Please ask for: Ms Iqraa Malik
Email: iqraa.malik@terraquest.co.uk
Telephone: 01212341390
Our Ref: LY/13/21/HH
Your Ref:
Date: 22nd July 2021

Application for Planning Permission for Works or Extension to a Dwelling

Development: Extension and conversion of out building into Office, Gym with WC and garage.
Location: Connies Byre Calceto Farm Calceto Lane Littlehampton BN17 7QL

BLOCK PLAN **SCALE 1:500 A3**
1:500 0m 5.0 10.0 15.0 20.0 25.0

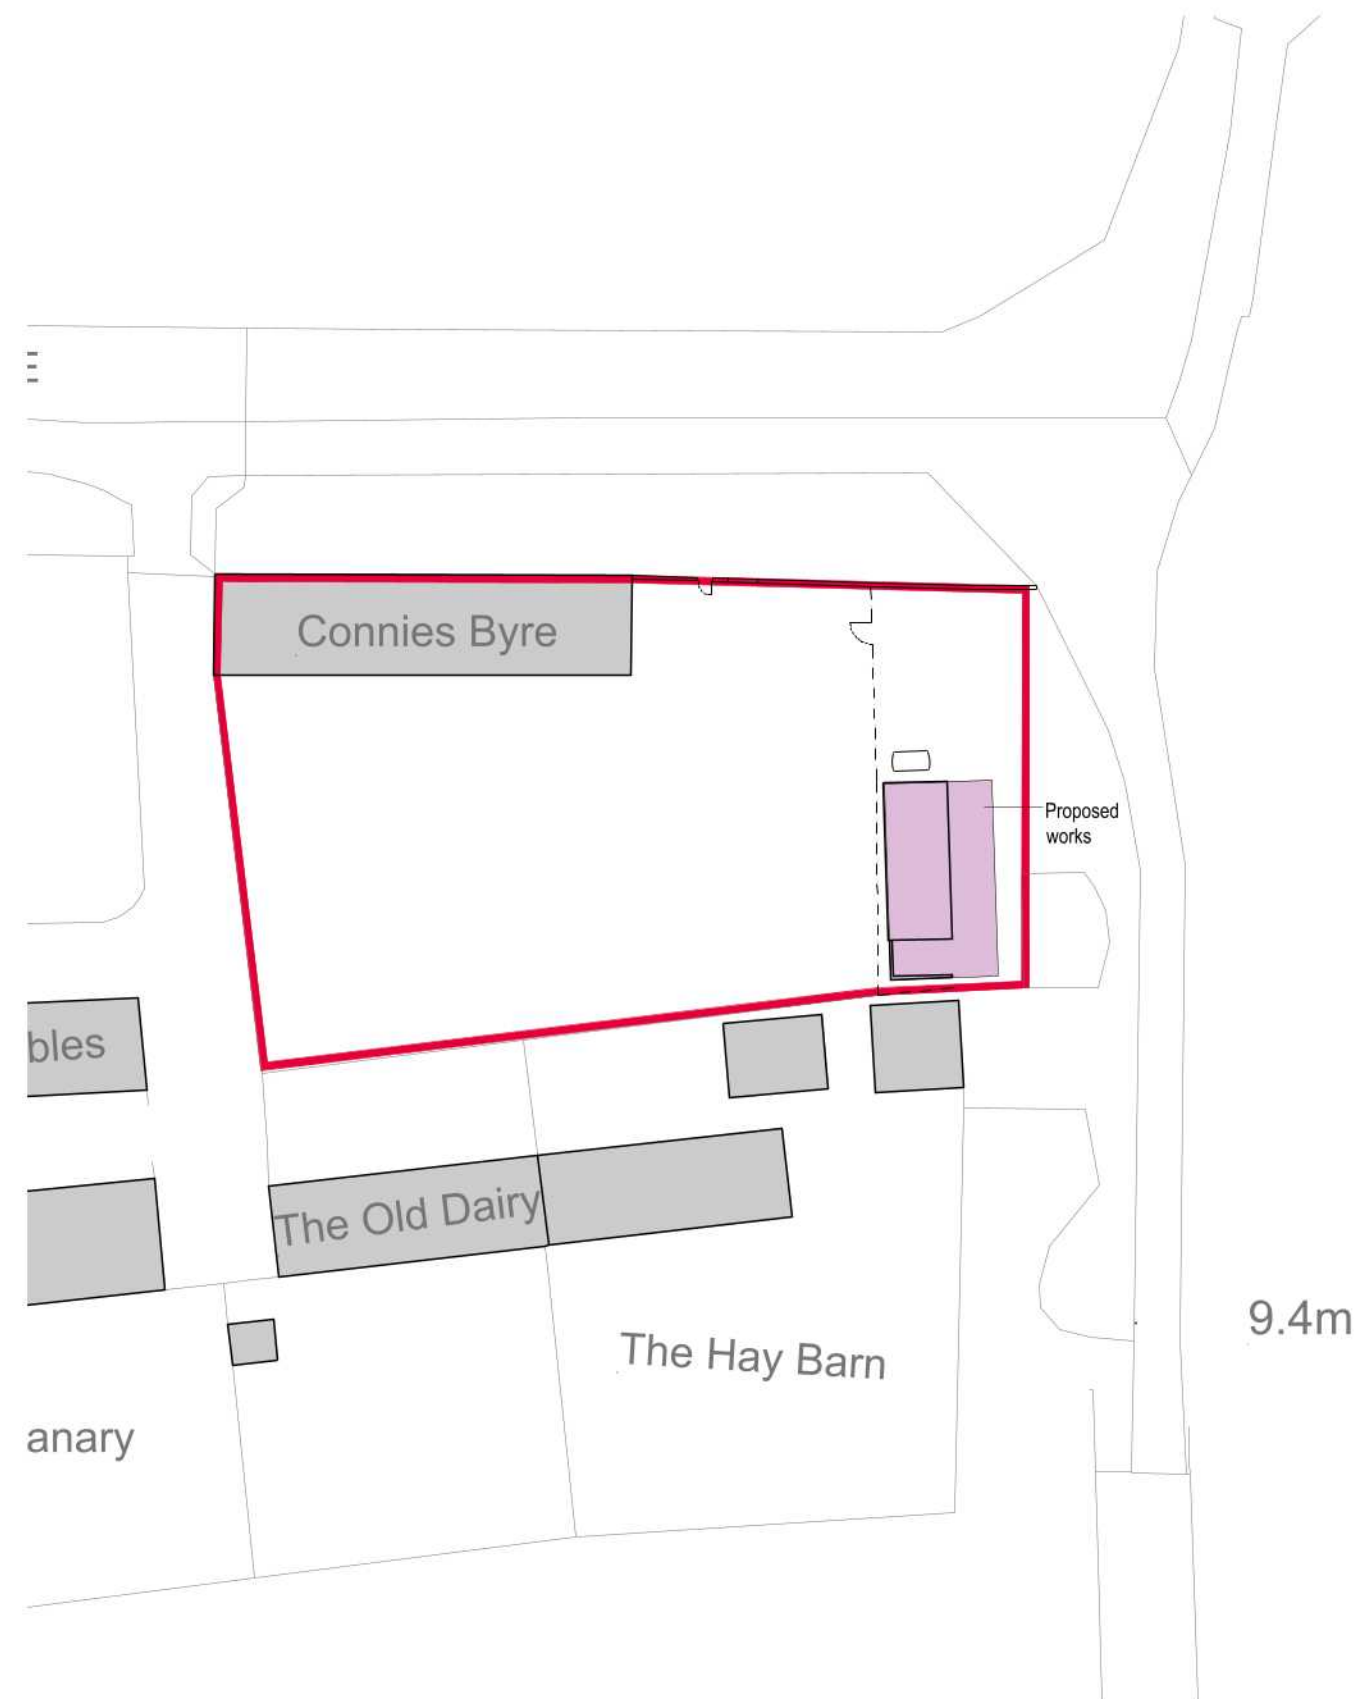
Block Plan

You are required to have dimensions from the proposed extension(s) to all site boundaries. Please amend.
